Link Road – Masterplan related and General Comments

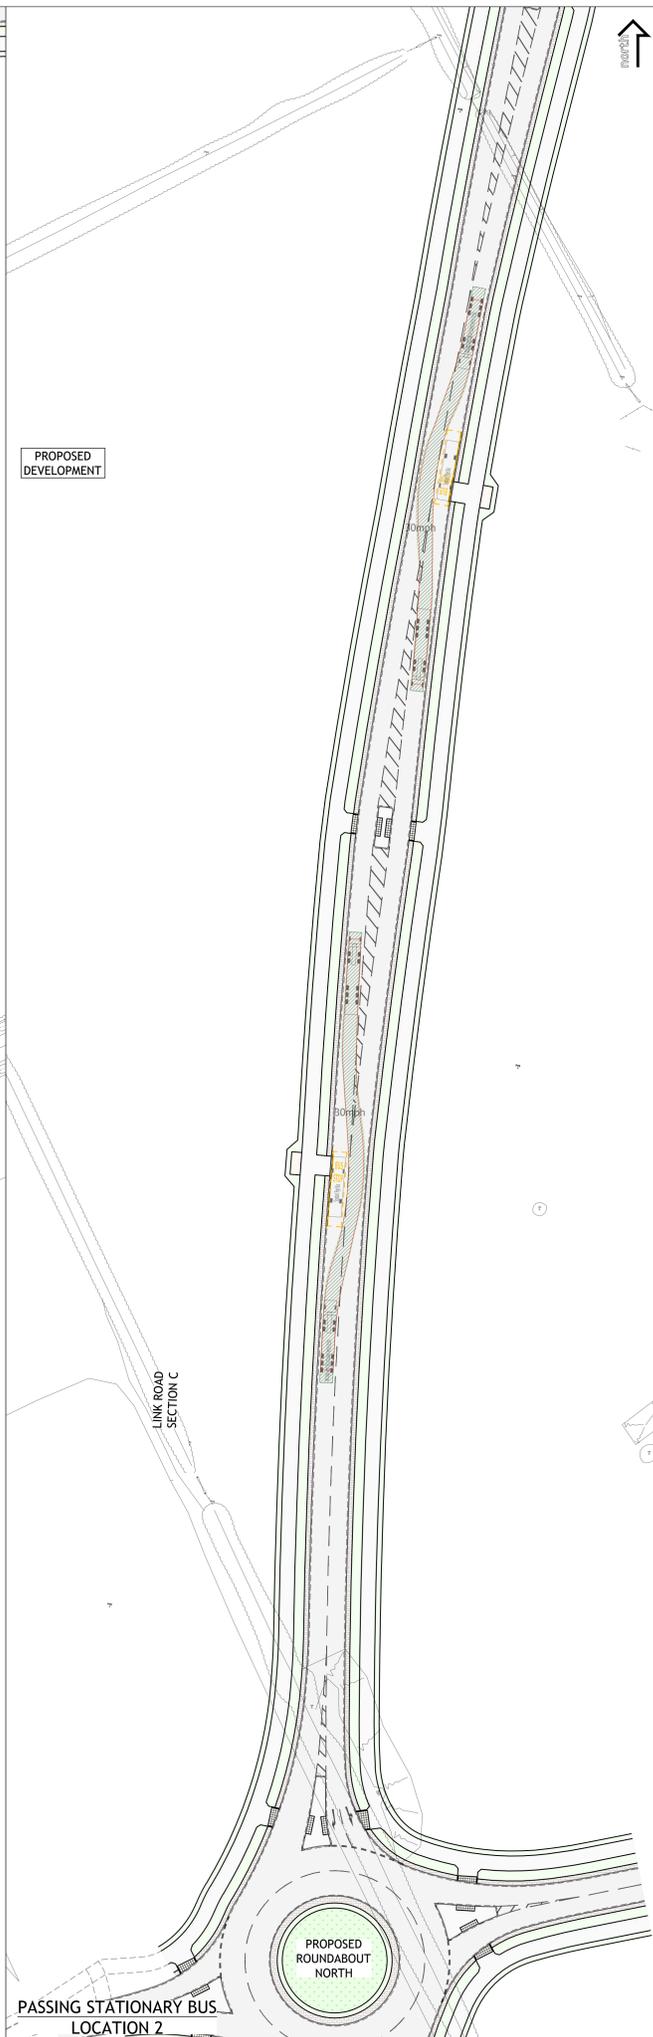
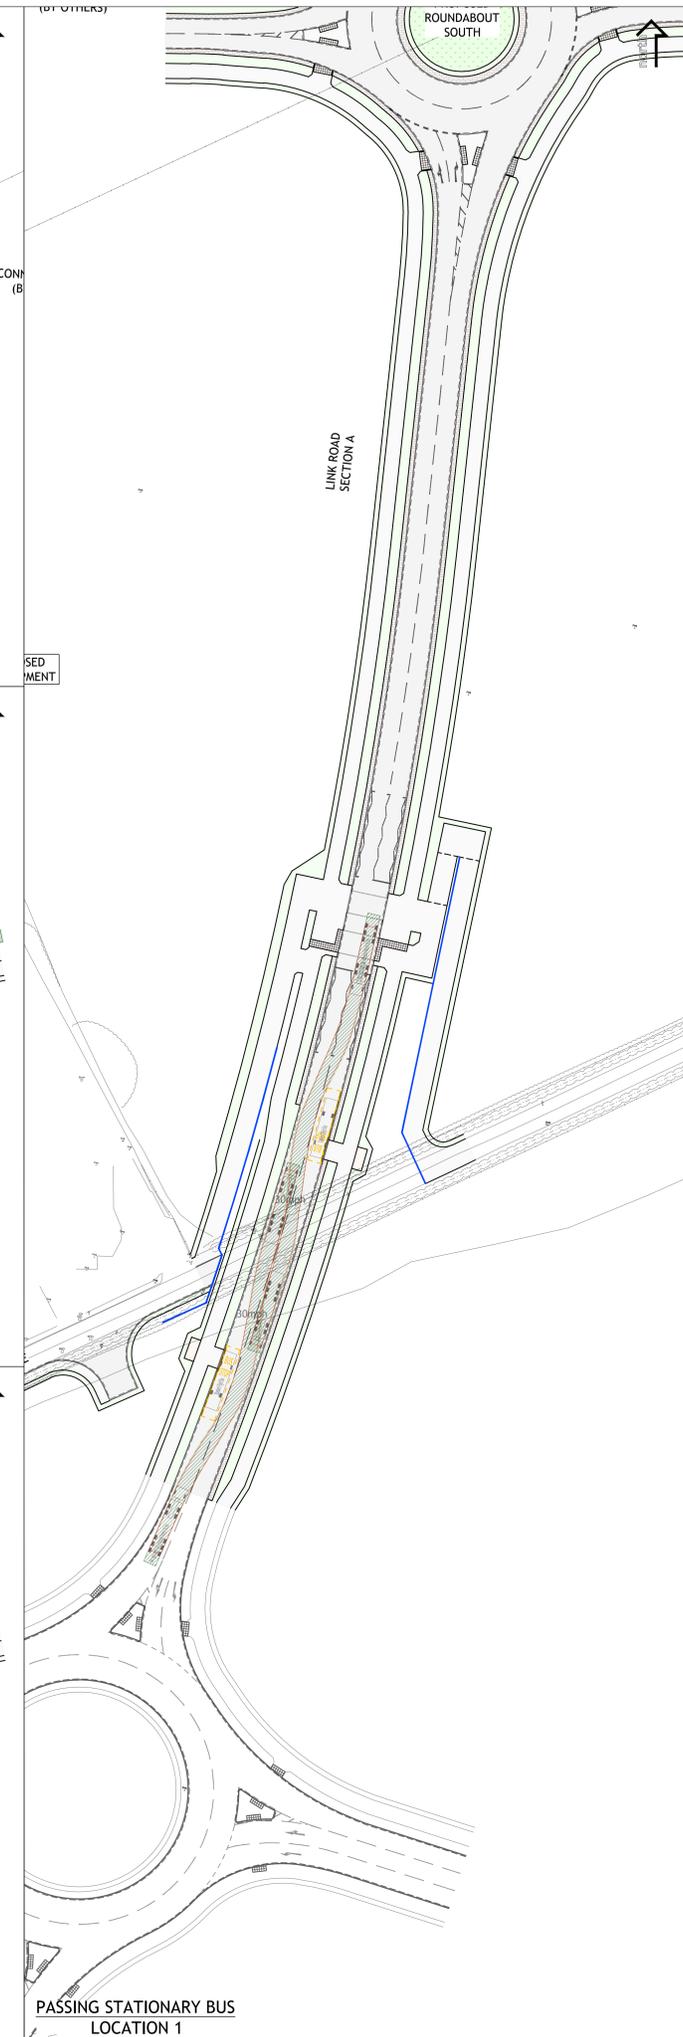
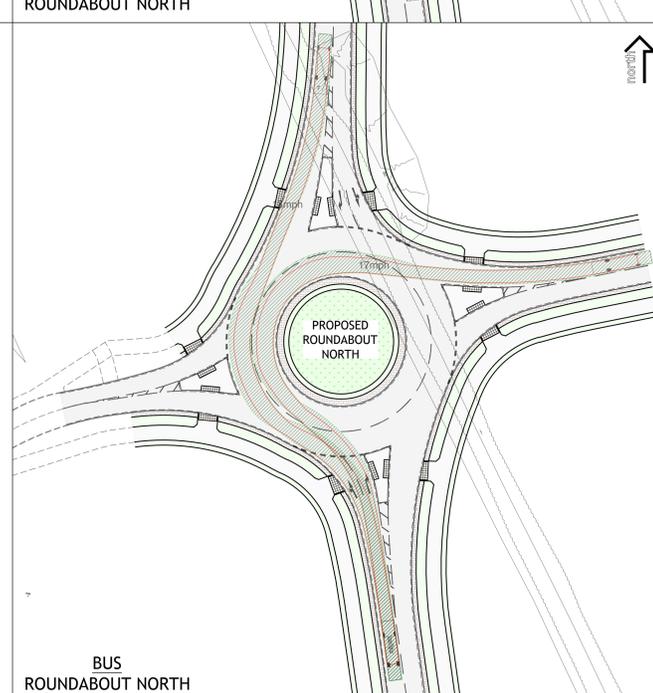
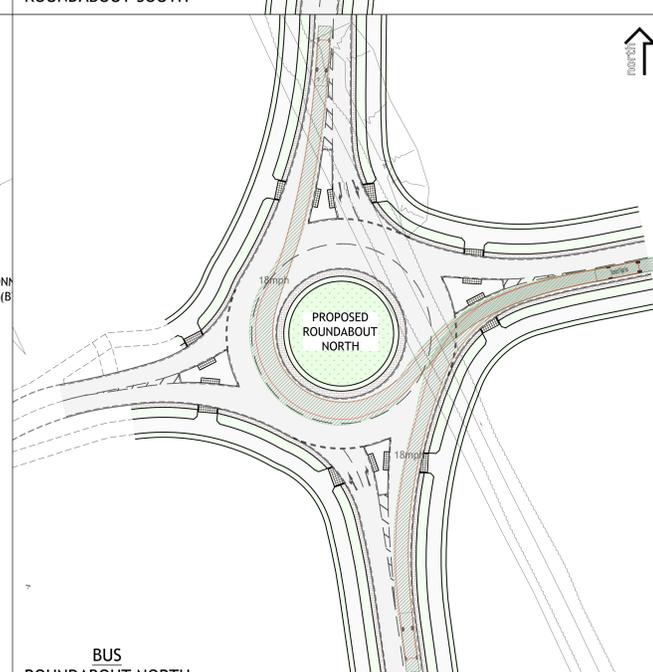
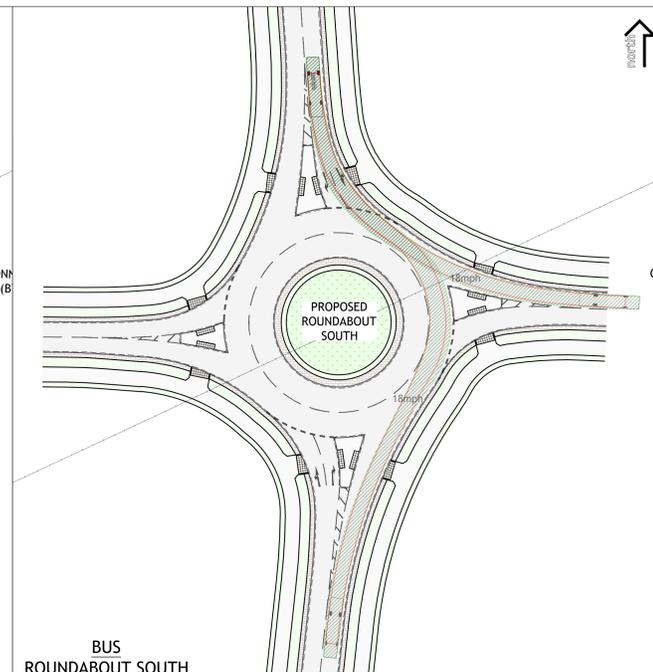
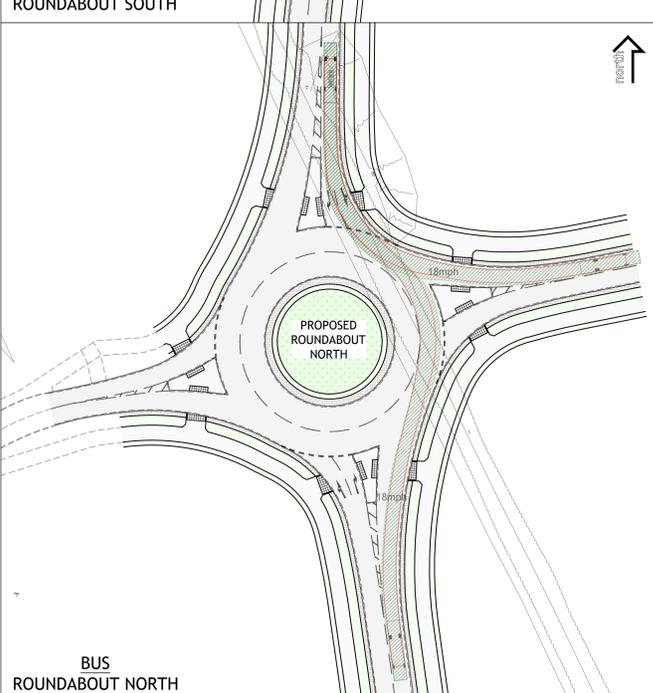
4. Swept Paths for the link road and internal northern and southern roundabouts are required using 16.5m articulated HGV's.

Roundabout South and North are tracked with 16.5m articulated HGV tracking (northbound/southbound directions) - DRG. 3062-100-P-011 SWEPT PATH ANALYSIS.
